DEVELOPMENT REVIEW BOARD
SUPPLEMENTAL SUBMITTAL

PROJECT NO. PR-2022-007229

Application No. SI-2022-01237

RE: Panda Express – S8-23-D20241
261 98th Street NW
Albuquerque, NM 87121
RE: DRB Planning Review – Resubmittal
DRB Project Number: 2022-007229
App. Number: SI-2022-01237

**NORTH-EAST ELEVATION 2**  
Scale= 3/16" - 1'0" A-202

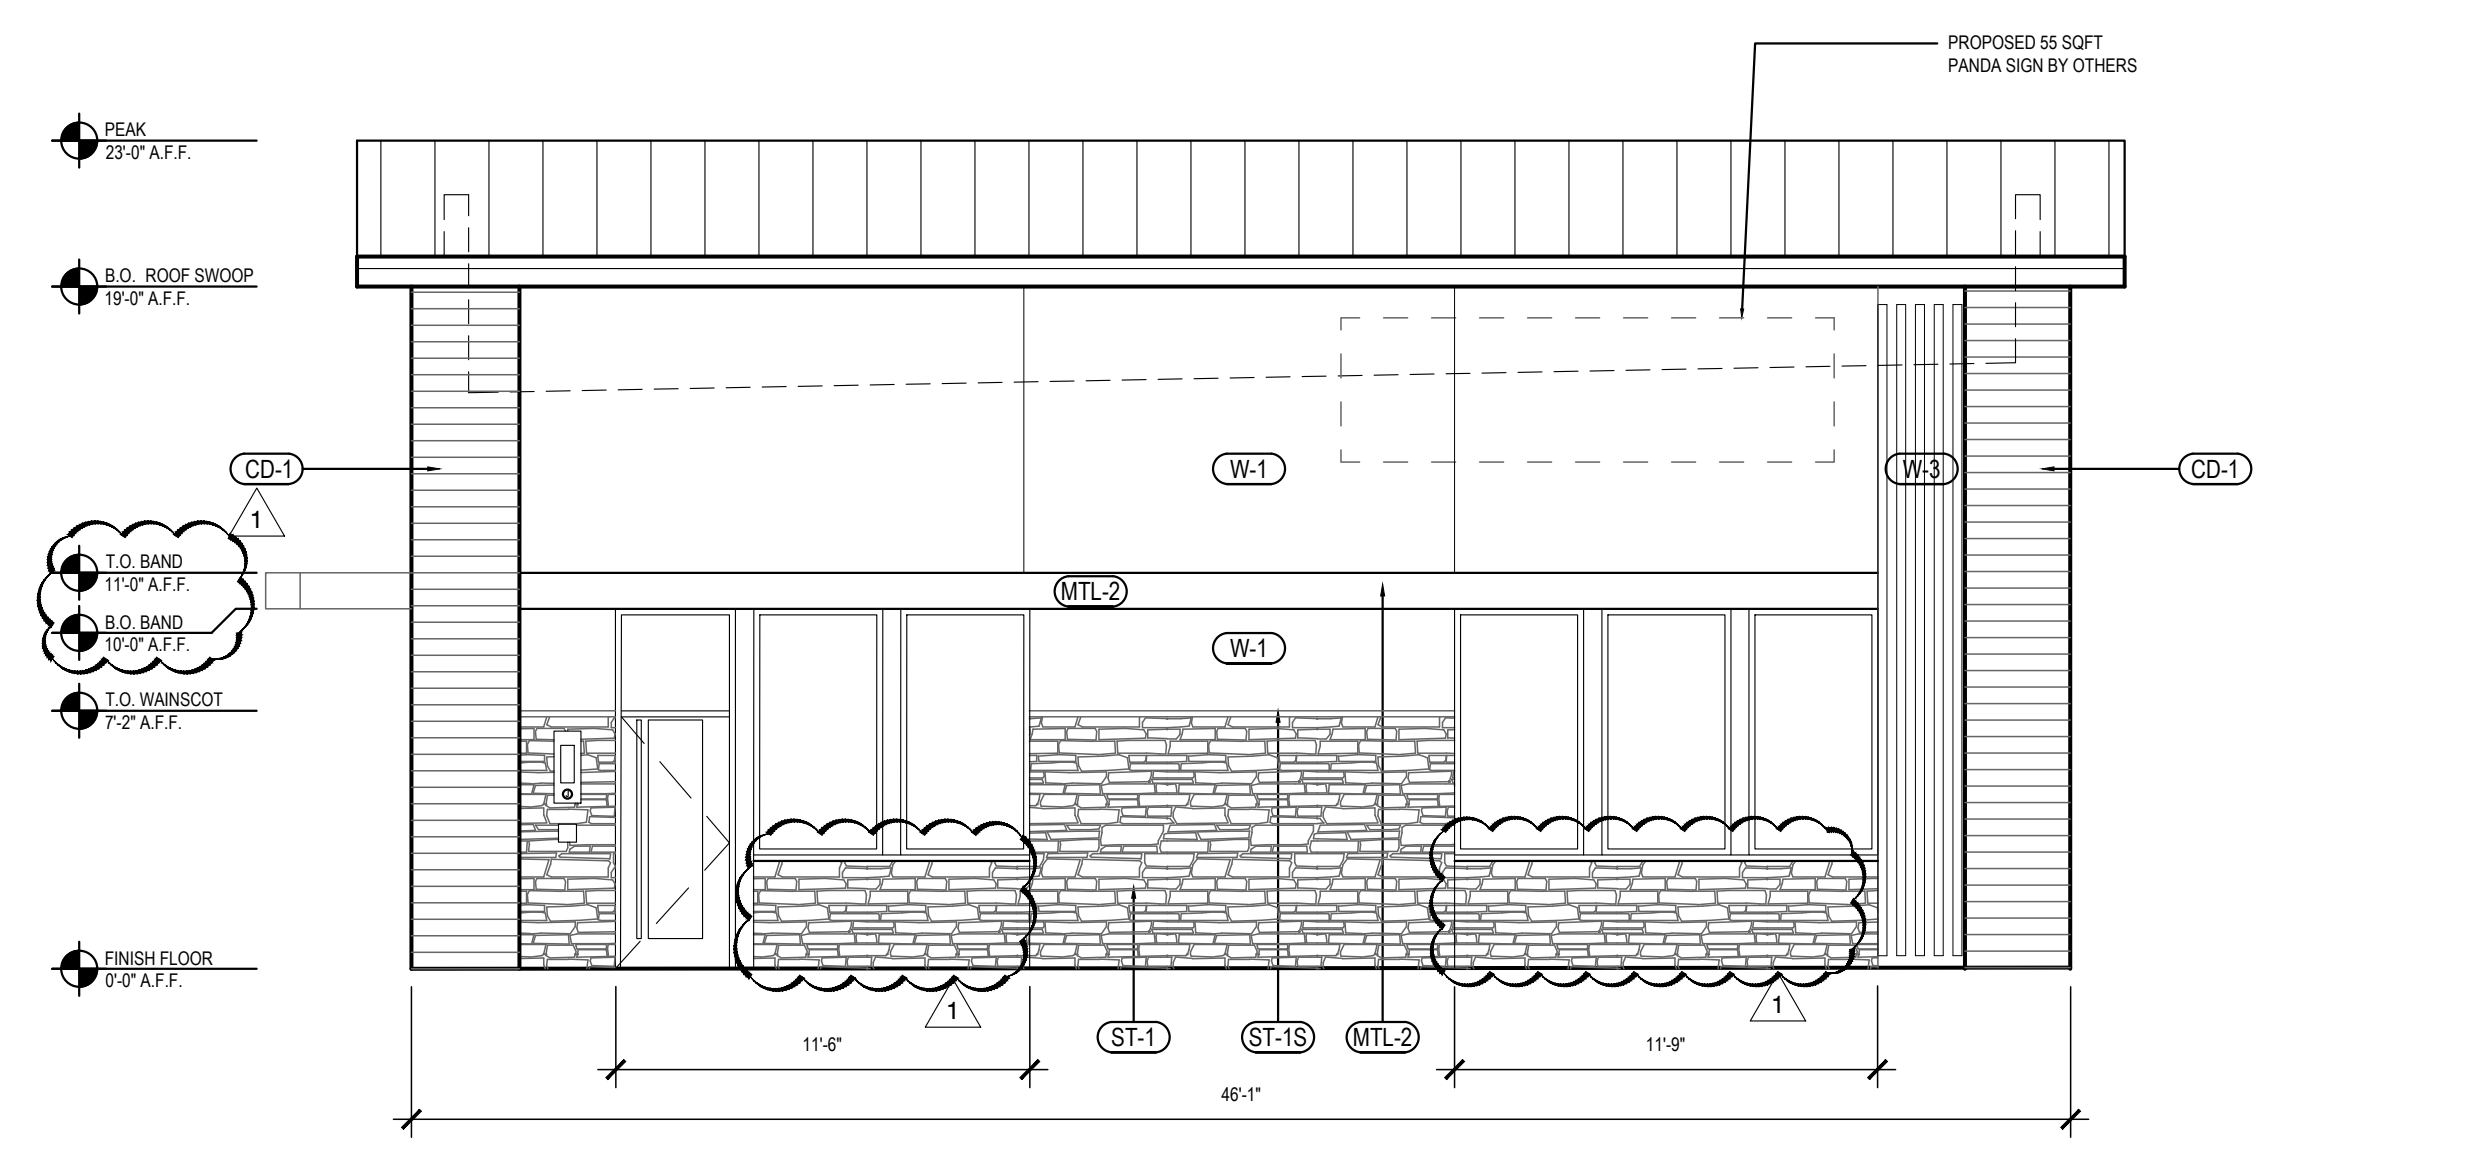
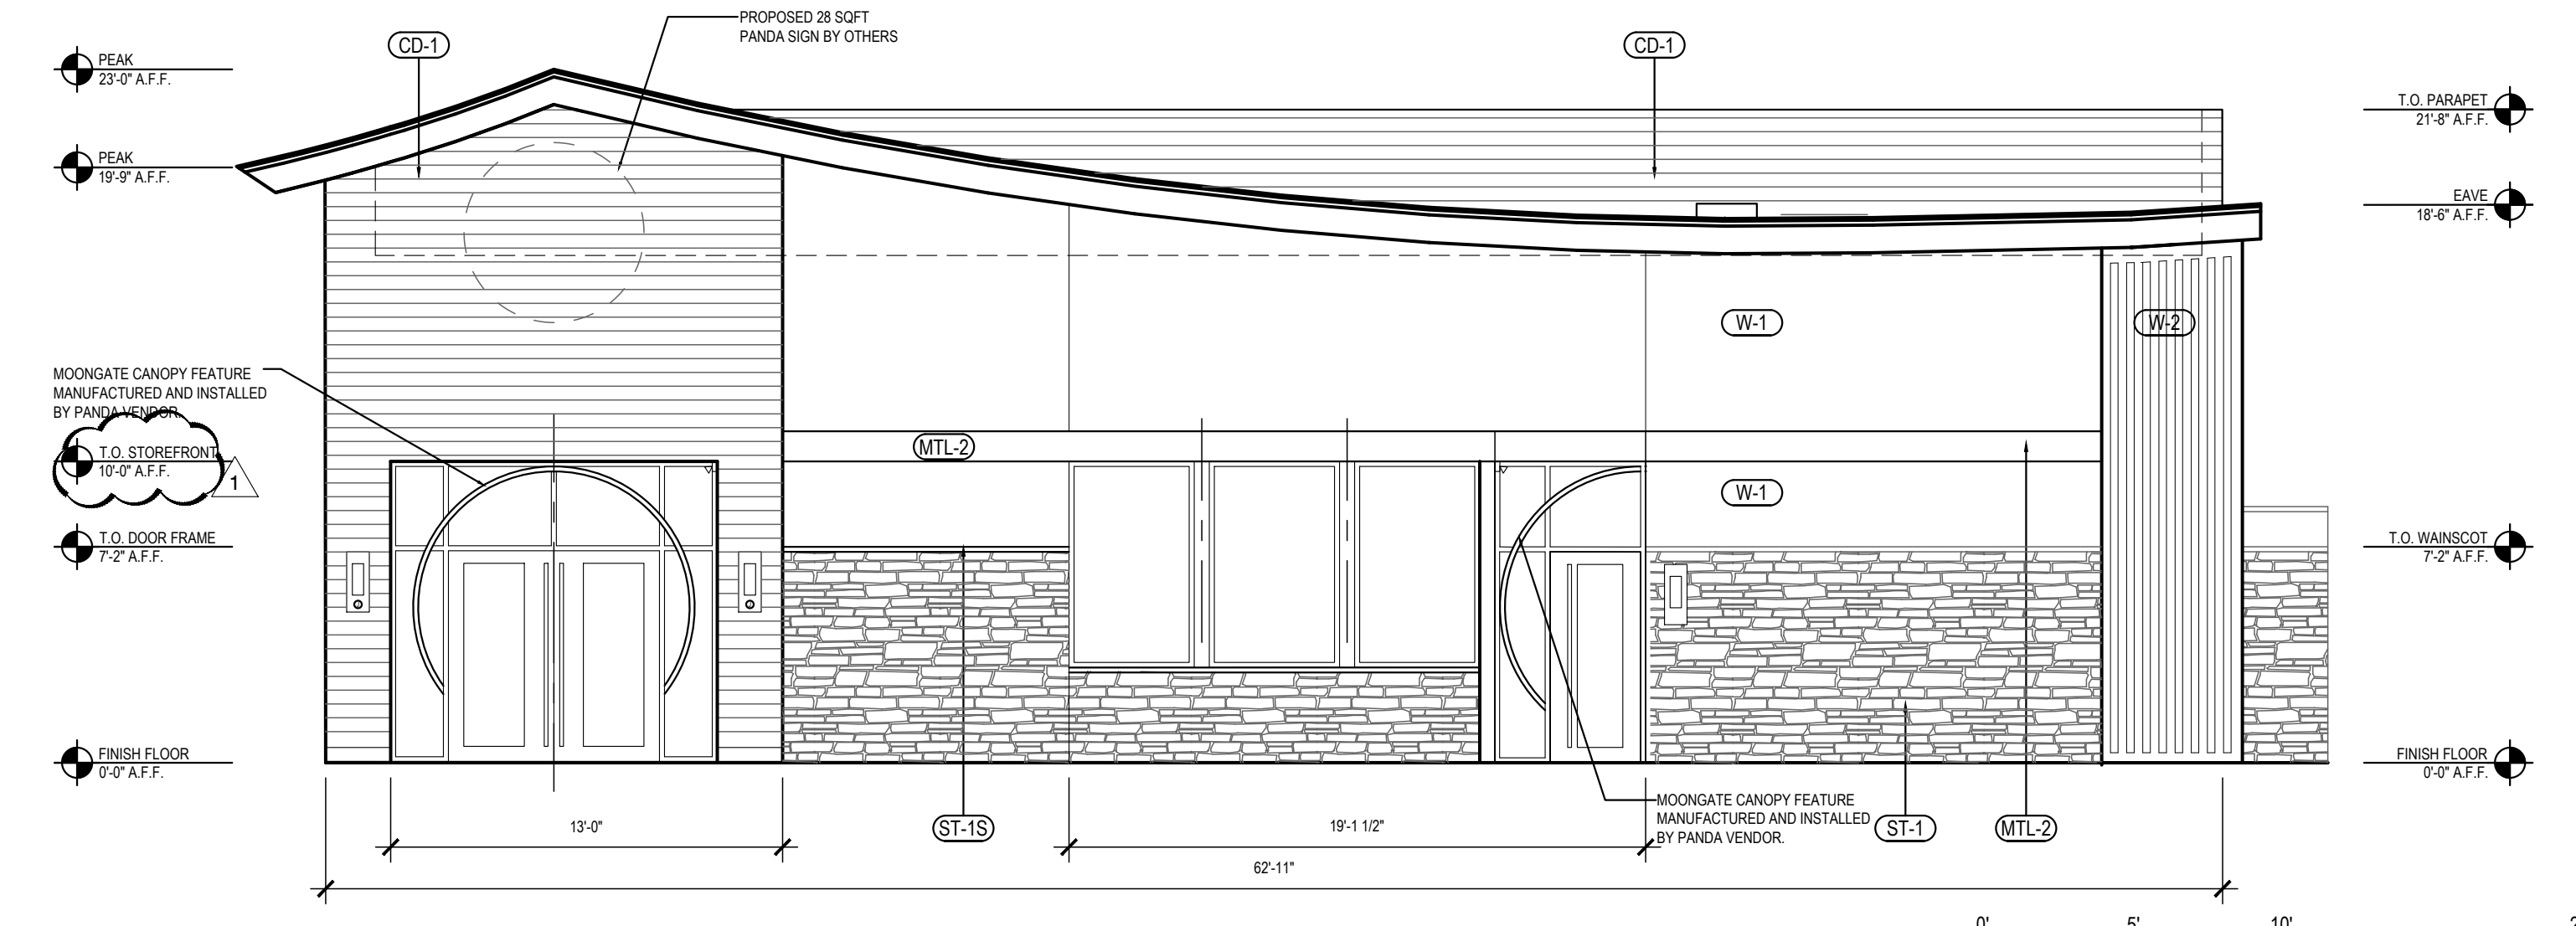
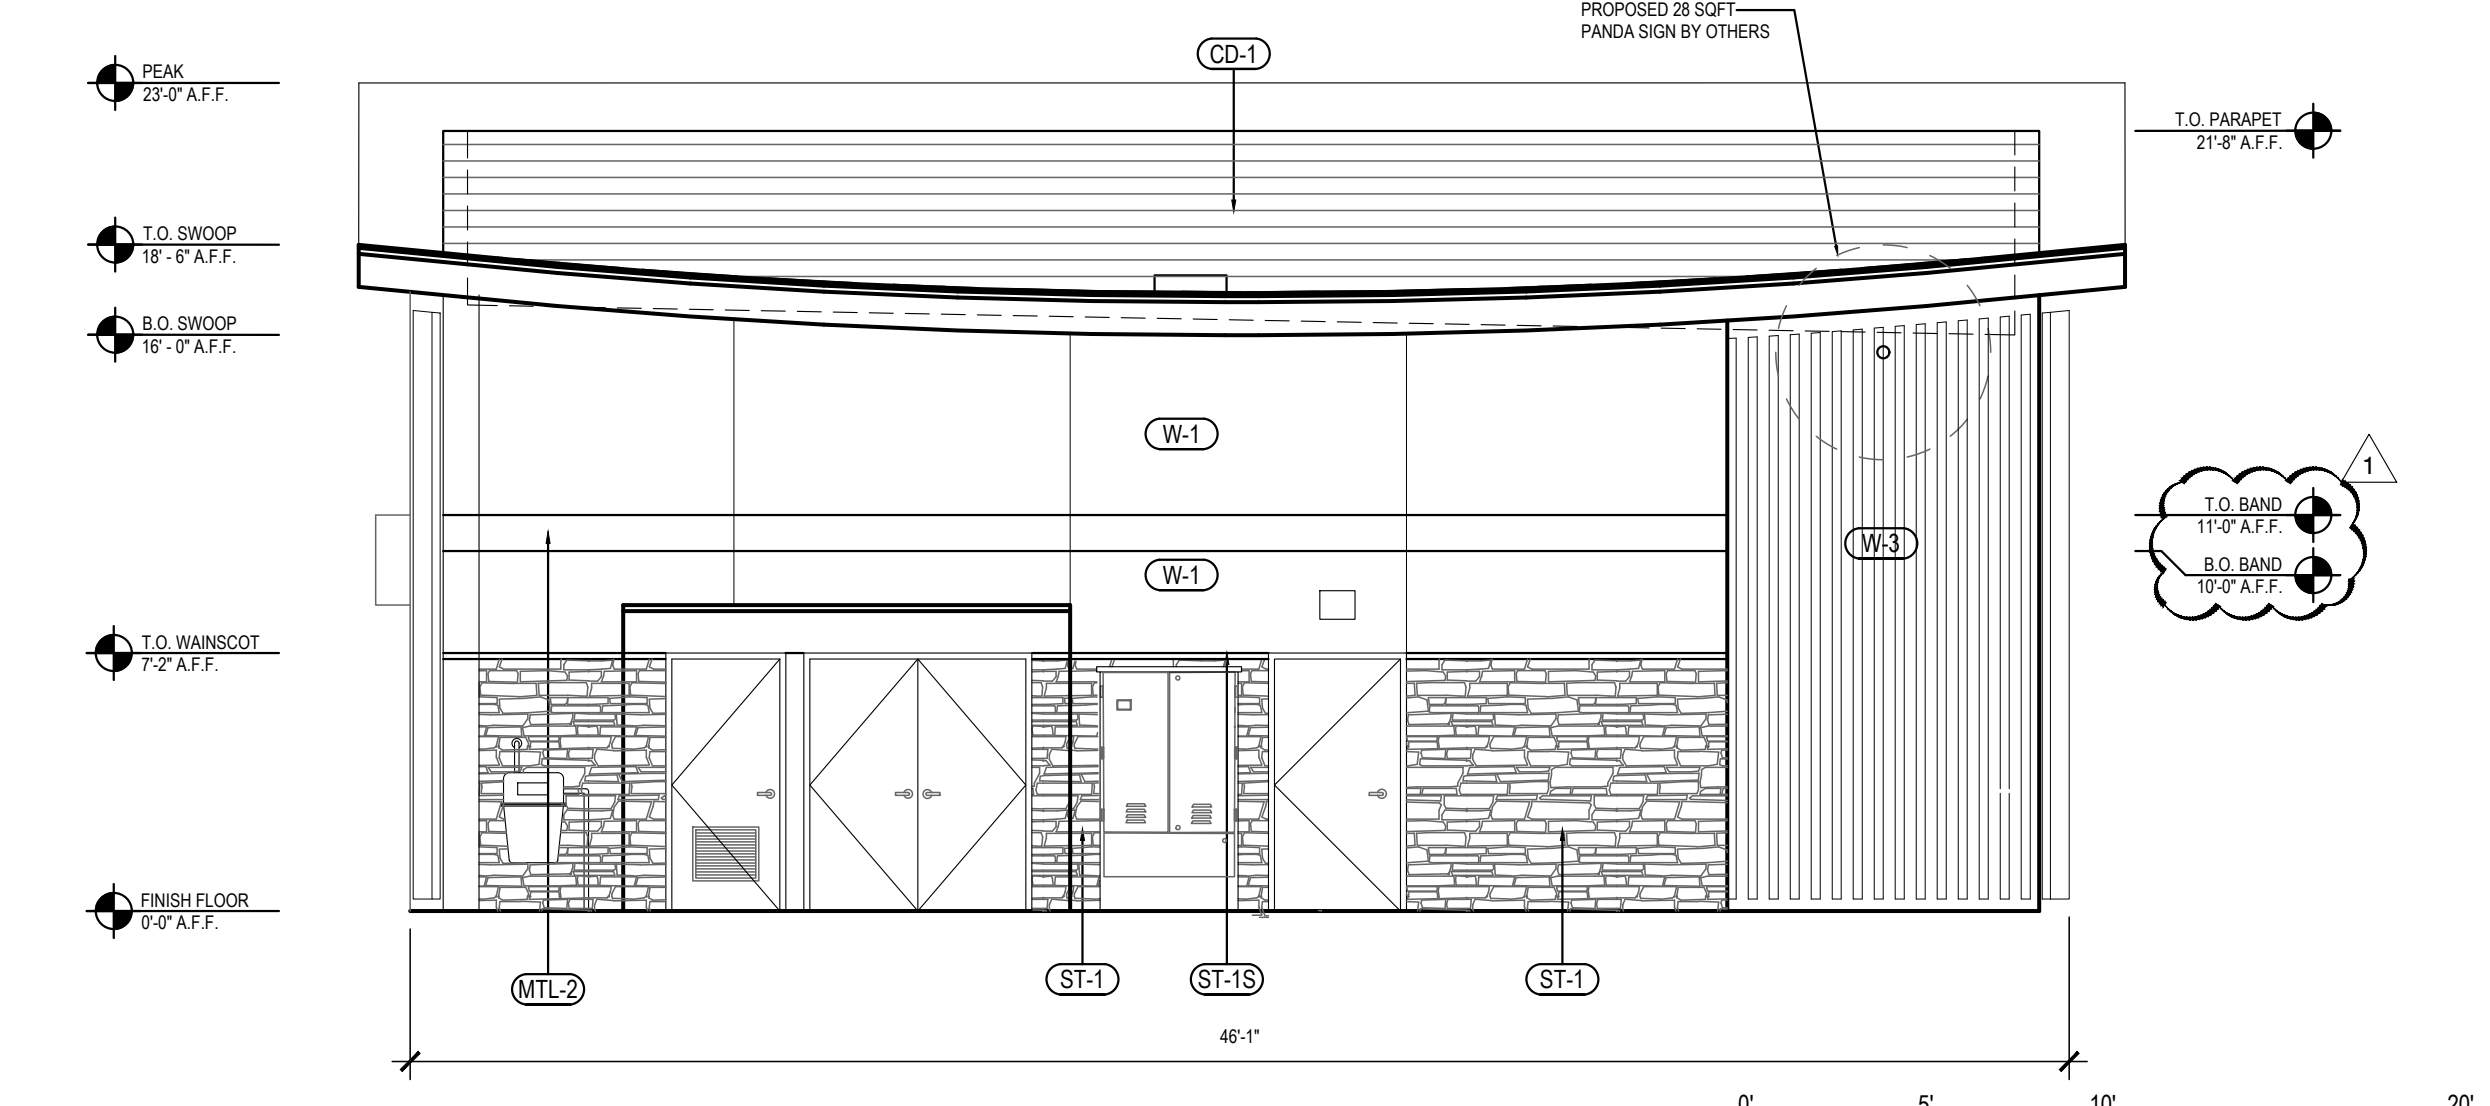
- The applicant is requesting a Deviation from the requirements for each ground floor of a street-facing façade to have a minimum of 30 percent of its surfaces in transparent windows per 5-11(E)(2)(a)2 of the IDO, noting that the proposed development is providing 25.1% of the surface of the street facing façade. To permit a DRB-approved Deviation, the reduction in the surface of a street facing façade being transparent windows. The amount of reduction in the surface of a street facing façade being transparent windows as proposed will require ZHE approval of a Variance.

Response: *Per IDO Section 5-11 E (2) (a) 2, each street facing façade shall incorporate at least 2 features along at least 30% of the length of the façade. Please reference to detail 2/A-202 for calculations under length of building.*

Response: *Acknowledge. Please reference detail 2/A-202, exterior elevations.*
